Town and Country Planning Act 1990 Prior Notification Application

Reference: H07-0079-15 Received: 4th February 2015

Description: Renovate existing brick built barn and outbuildings and change the use to a three-bed residential unit - resubmission of H07-0685-14

Location : The Barn West Drove North
Gedney Hill Spalding

Drawing No.
02B

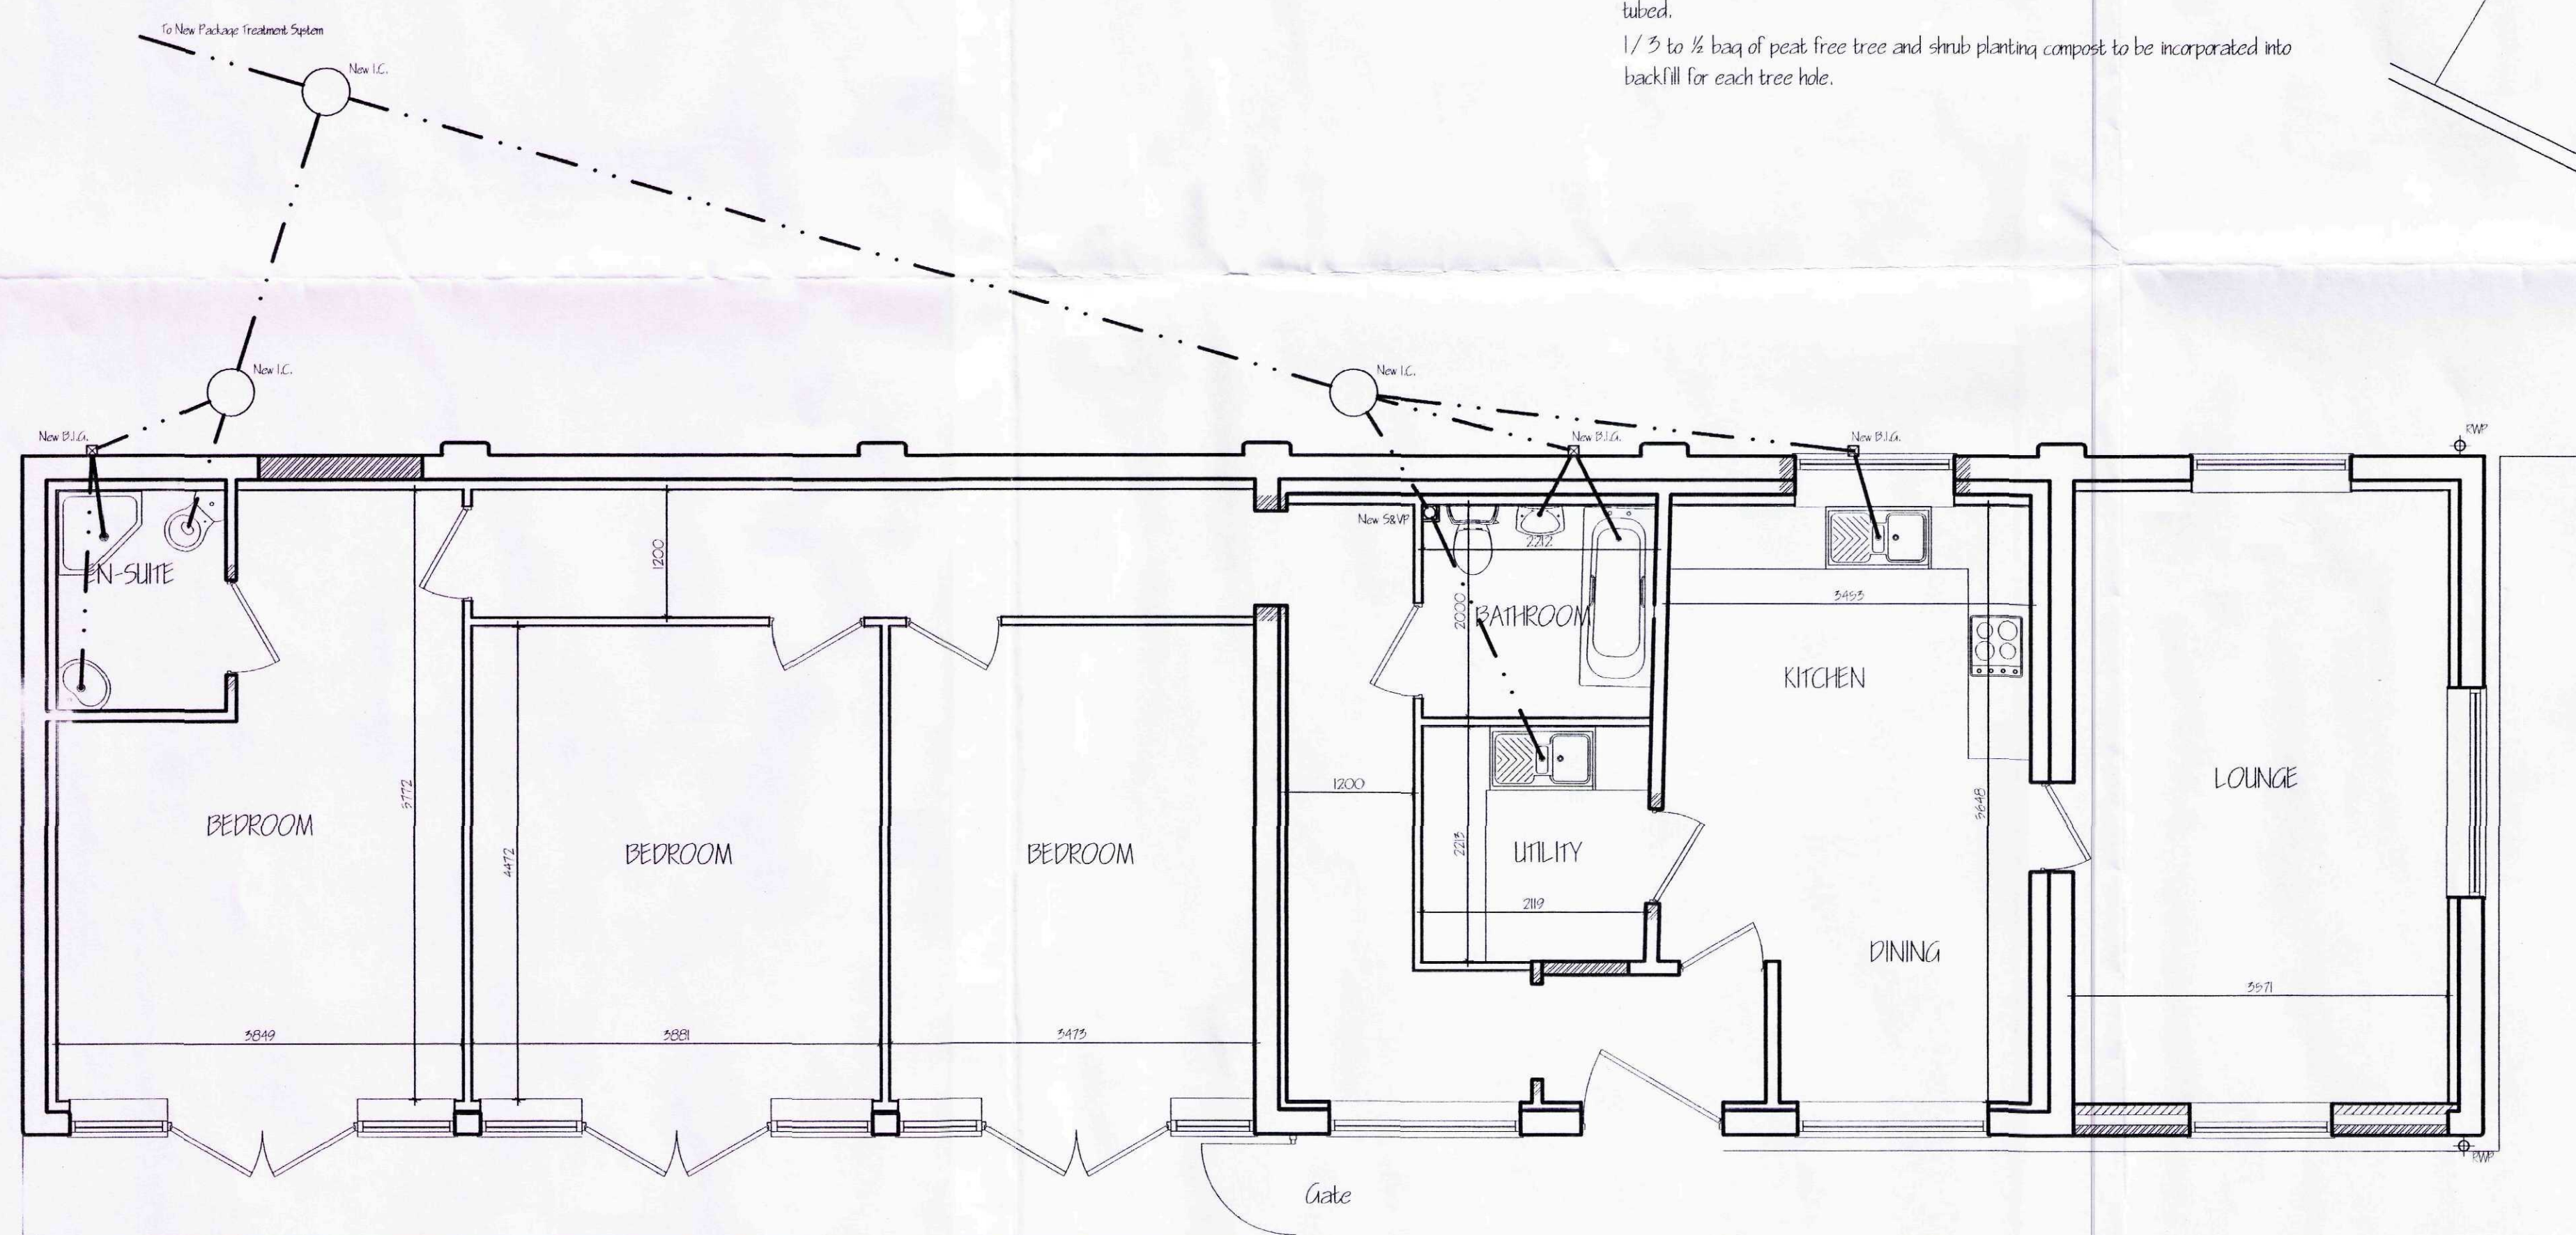
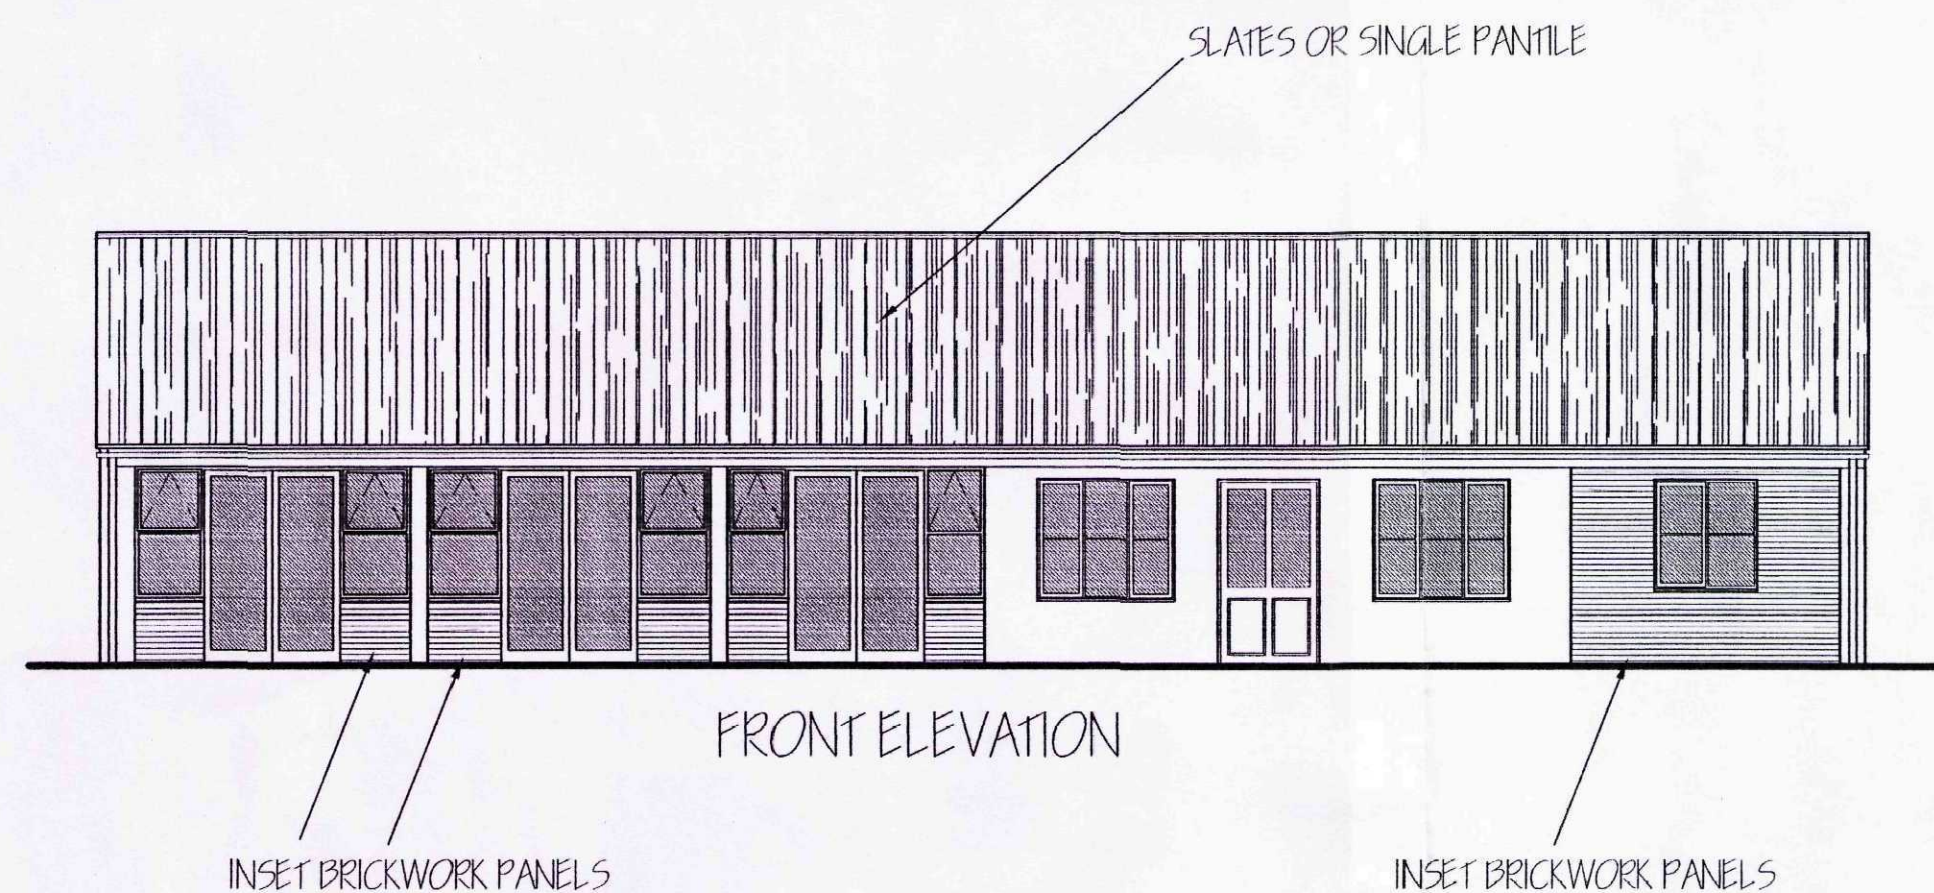
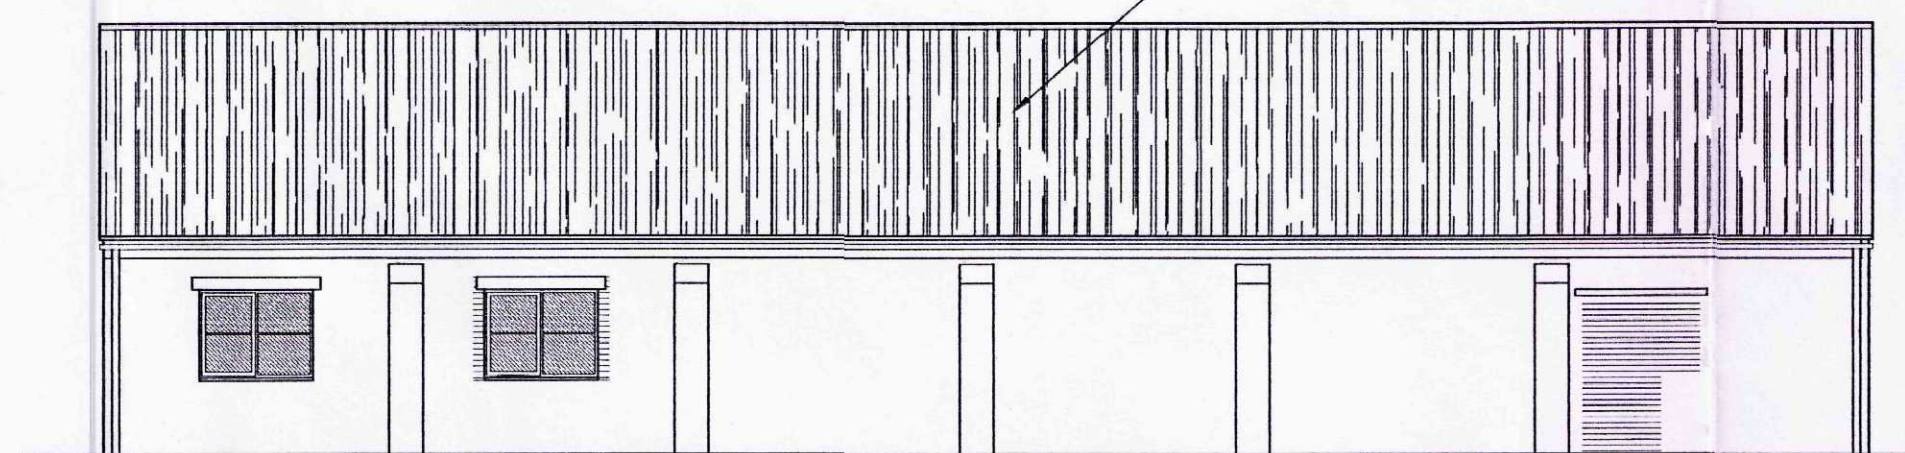
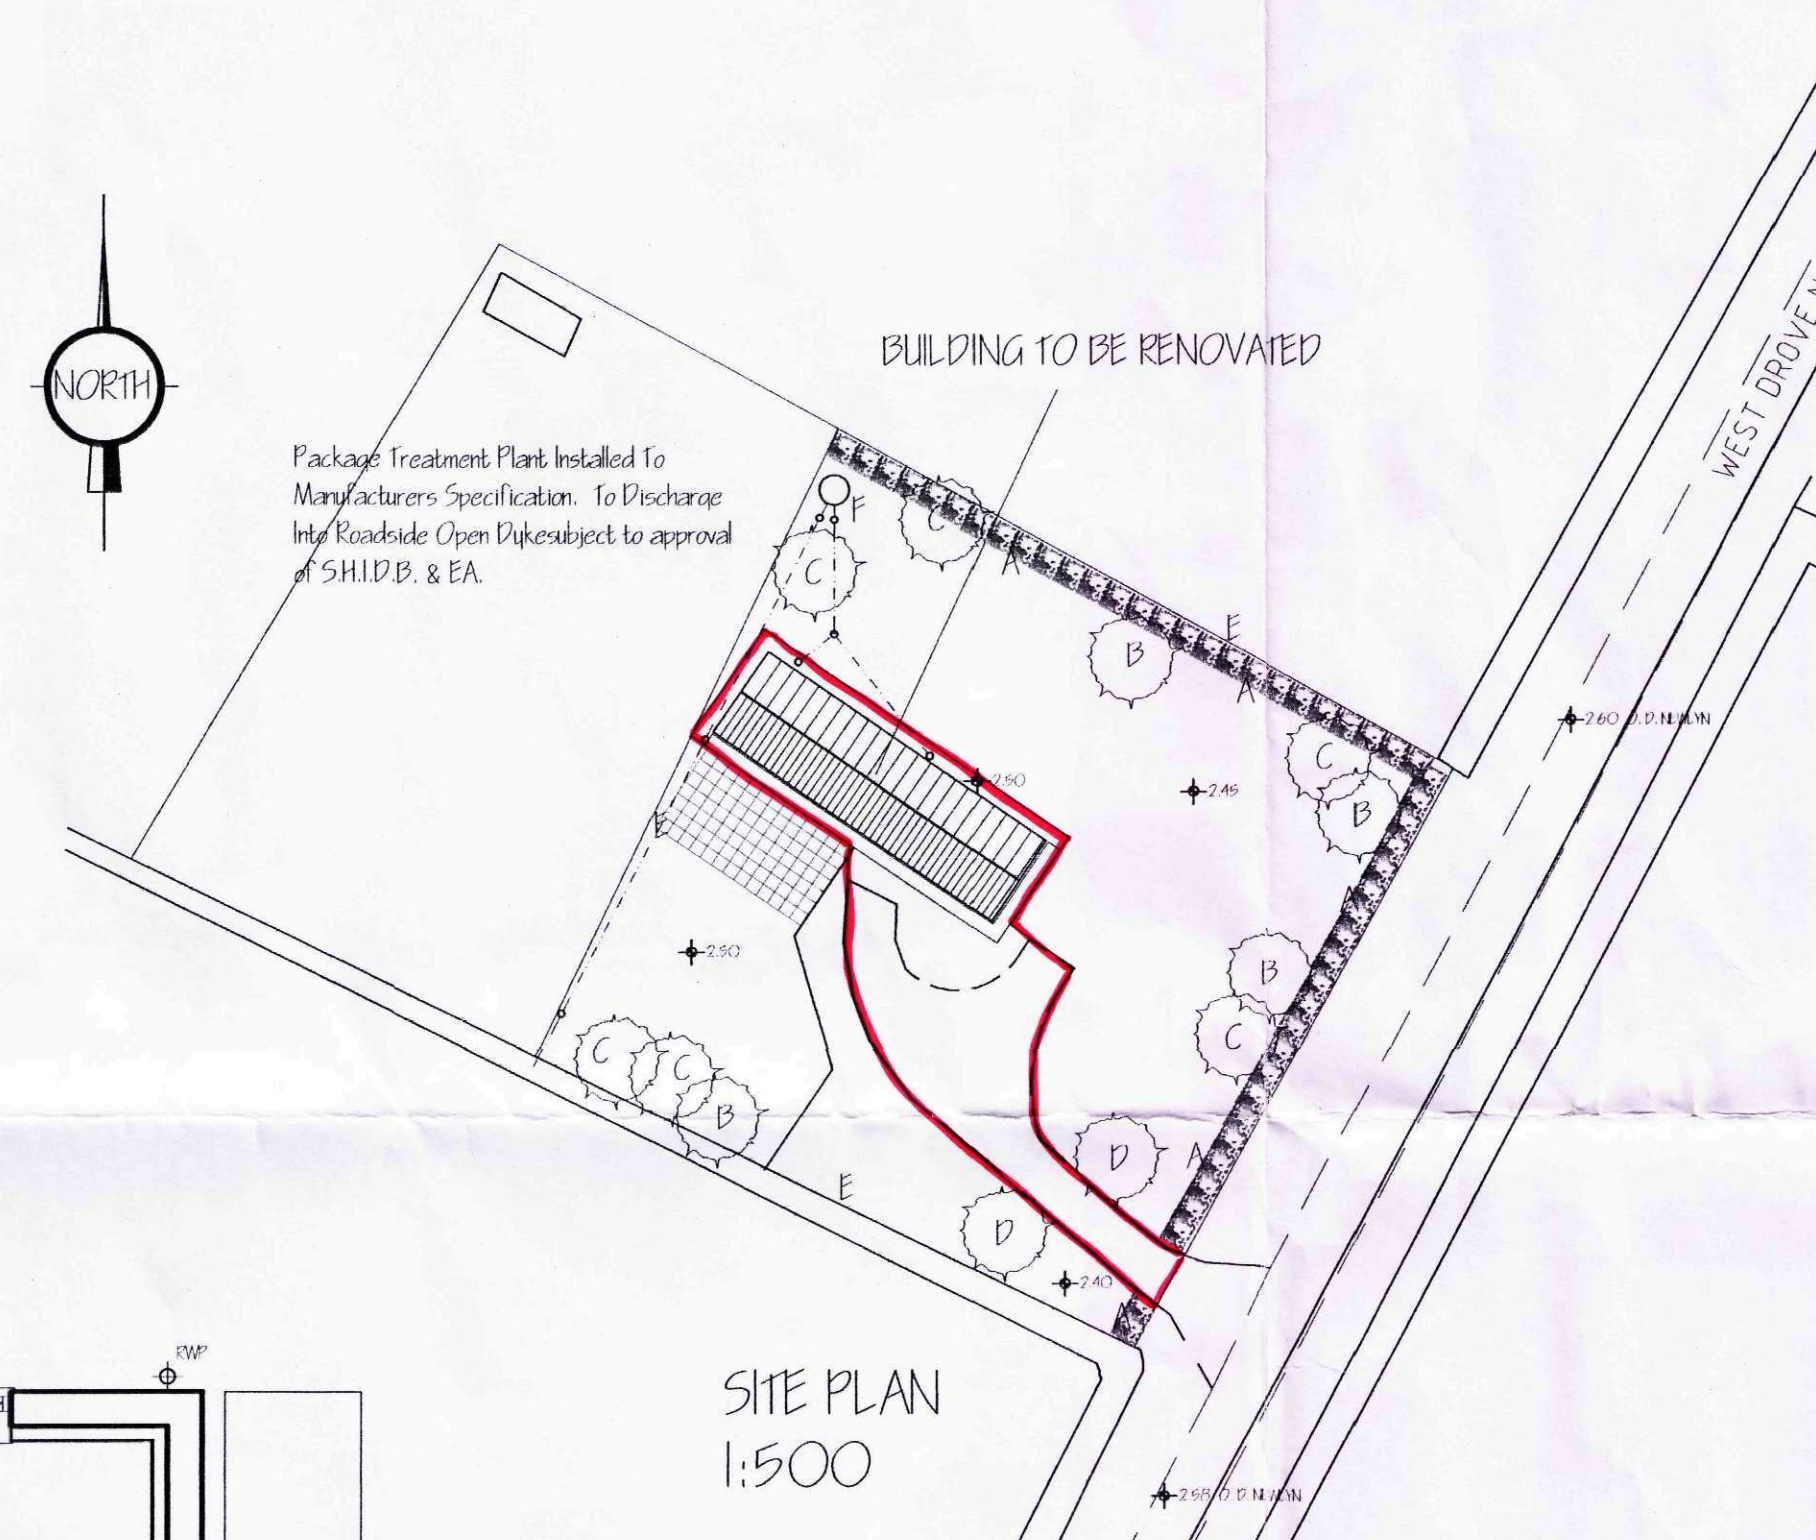
Moreover, only the easternmost part of the building presently exists in its entirety. The westernmost section has largely been removed, with only two walls remaining. As a consequence, the proposed development would result in the external dimensions of the building extending beyond the external dimensions of the existing building and would involve buildings operations beyond those reasonably necessary to convert the building to a dwelling.
